Re: Weigall Sports Complex, Sydney Grammar School
DA SSD-10421

I am making a comment on conditions of consent that should be included in the approval of this development which I support.

Figure 30 - Temporary Pedestrian Access on Alma Street

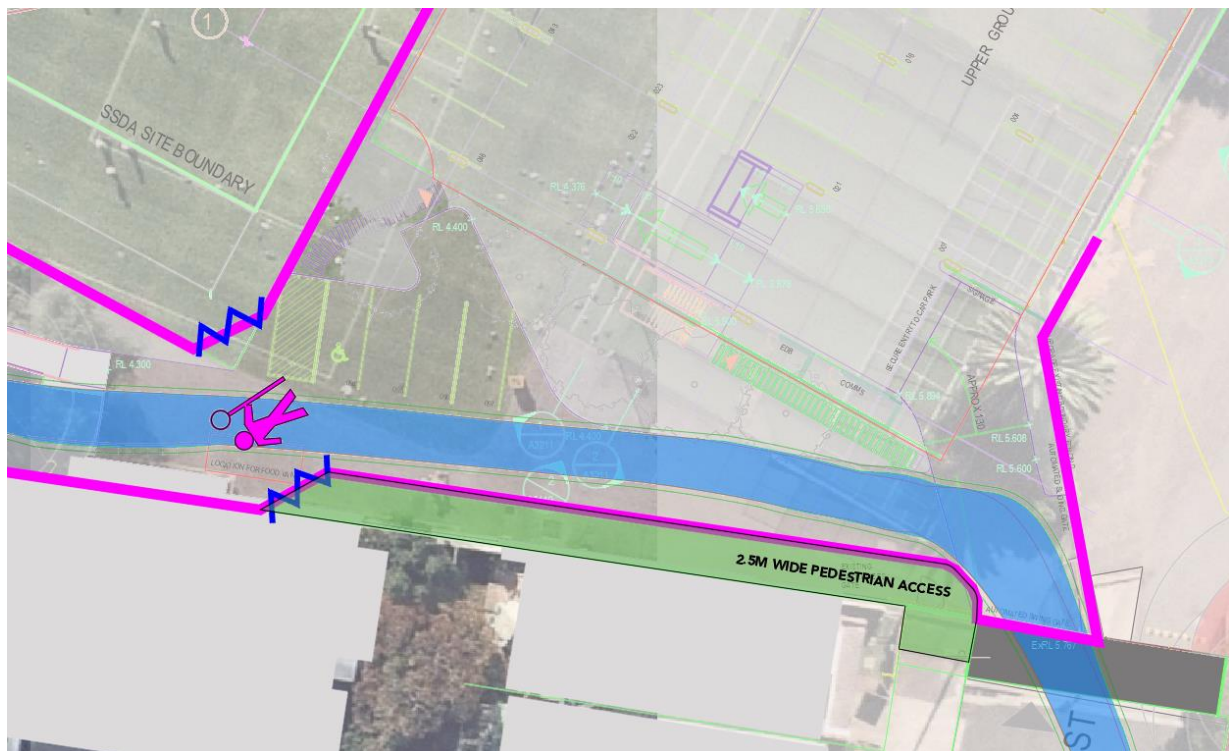
Construction traffic for Building 2 Weigall Sports Complex Carpark will exit via Alma St where the preparatory school is located. The exiting vehicles will cross a footpath that is used all day by students of the School. These children - as young as 5 years of age - wear sun hats and run with their heads down so that the hat visor obscures forward views, have ears filled with the laughter of their friends and are generally oblivious to the dangers of the world, including exiting vehicles.

The traffic management plan (Appendix H) details no traffic control measure such as a gate controller at the point of egress of construction traffic via Alma Street, including the footpath crossing. A traffic control measure at the point of egress to Alma St should be a condition of consent.

The traffic management plan states construction vehicle movement will be restricted during the school peak periods times between “8.00am-9.30am and 2:30pm-4:00pm”. School starts at 8:30 am and drop offs start from 7:30 am so construction traffic should be restricted from 7:30 am.
